February 2, 2018
Summit #17004

Reference: Geotechnical Engineering Report Addendum – Proposed Building
50 Cove Street, Portland, Maine

The following section is intended to supersede Section 5.1 of the original geotechnical report. All other sections of the report remain applicable.

Slab Subgrade Preparation and Design

SECTION **A** 3/4"=1'-0" S2.1

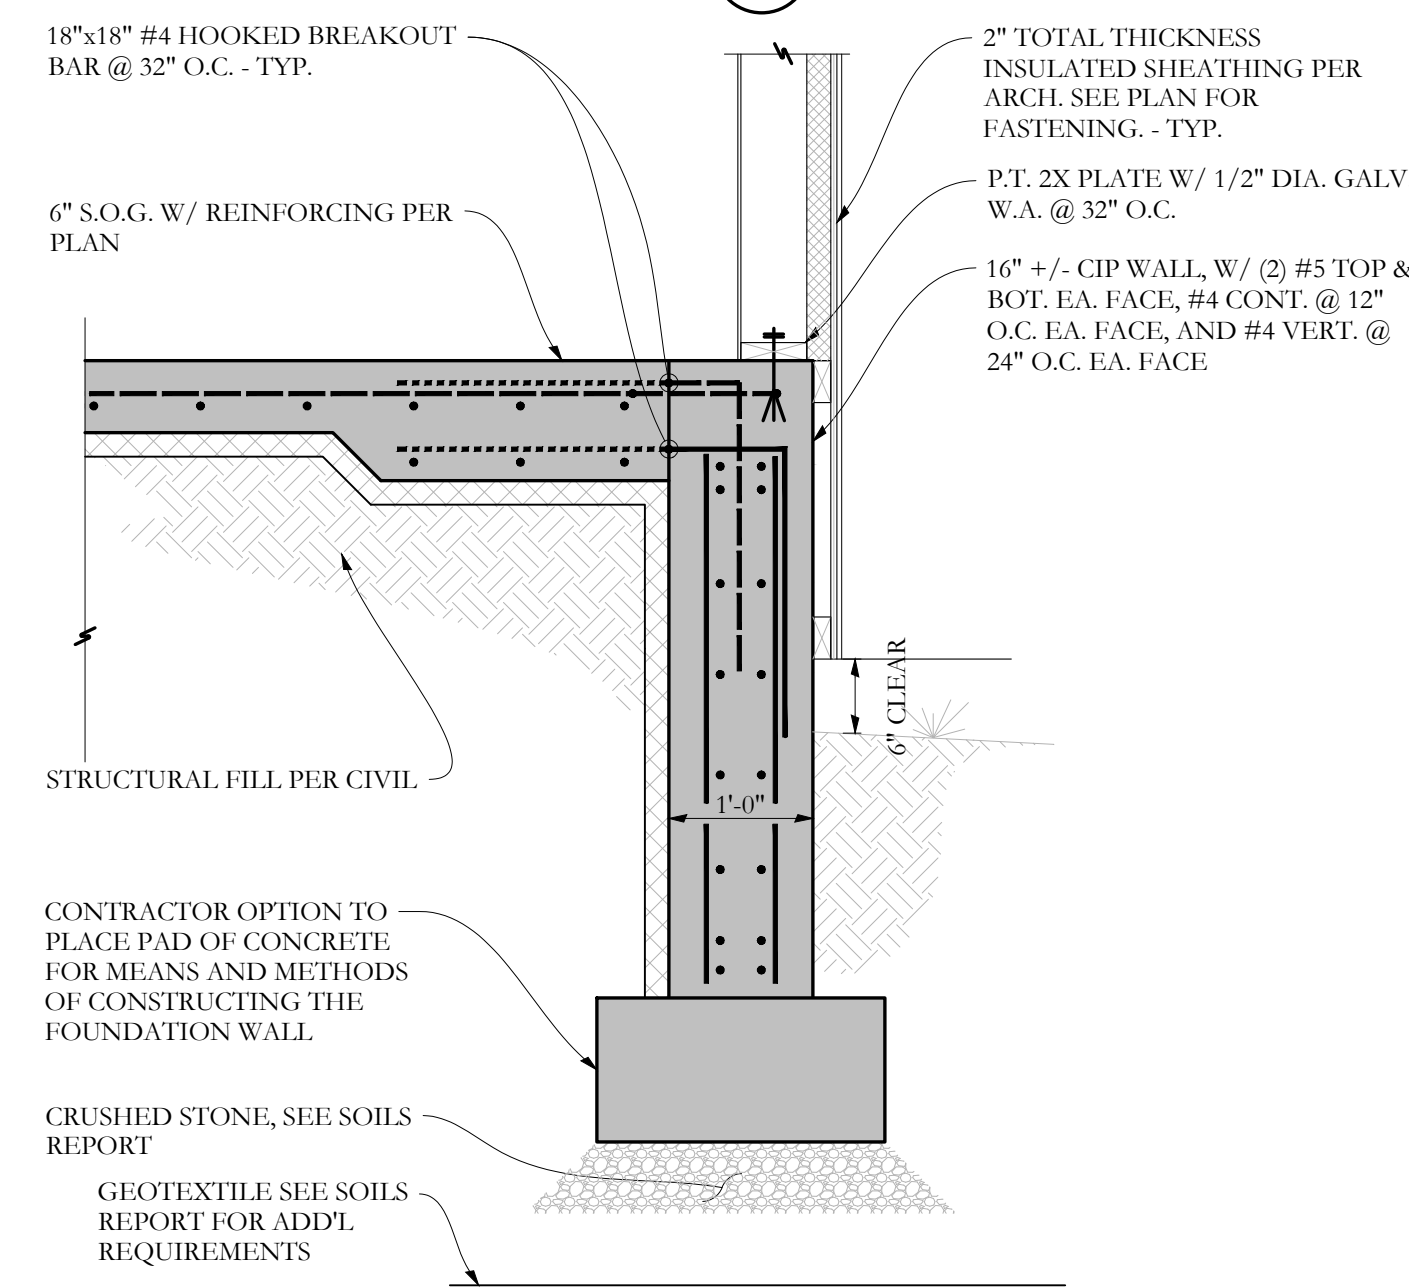
- TriAx TX160 triaxial geogrid is installed on top of proofrolled subgrade and beneath the perimeter haunch of the slab. Assuming the haunches are 12" thick, the triaxial geogrid should be centered beneath the haunch and extend a minimum of 30" beyond both edges (total geogrid width of 72"). Seams should be overlapped a minimum of 12." The geogrid should be pre-tensioned and staked prior to placing the crushed stone or SF on top of it.

- The exterior haunch is structurally tied to the mat to prevent concentrated loads beneath the haunch. If any cold joints are required to construct the slab and haunch, they should be adequately designed to transfer all axial loads, shear forces, and moments to the slab. Interior columns are supported on thickened slab sections and not on independent footings.

Refer to the attached geogrid layout plan and detail. SGS should be retained to observe the foundation subgrade during the proofrolling process.
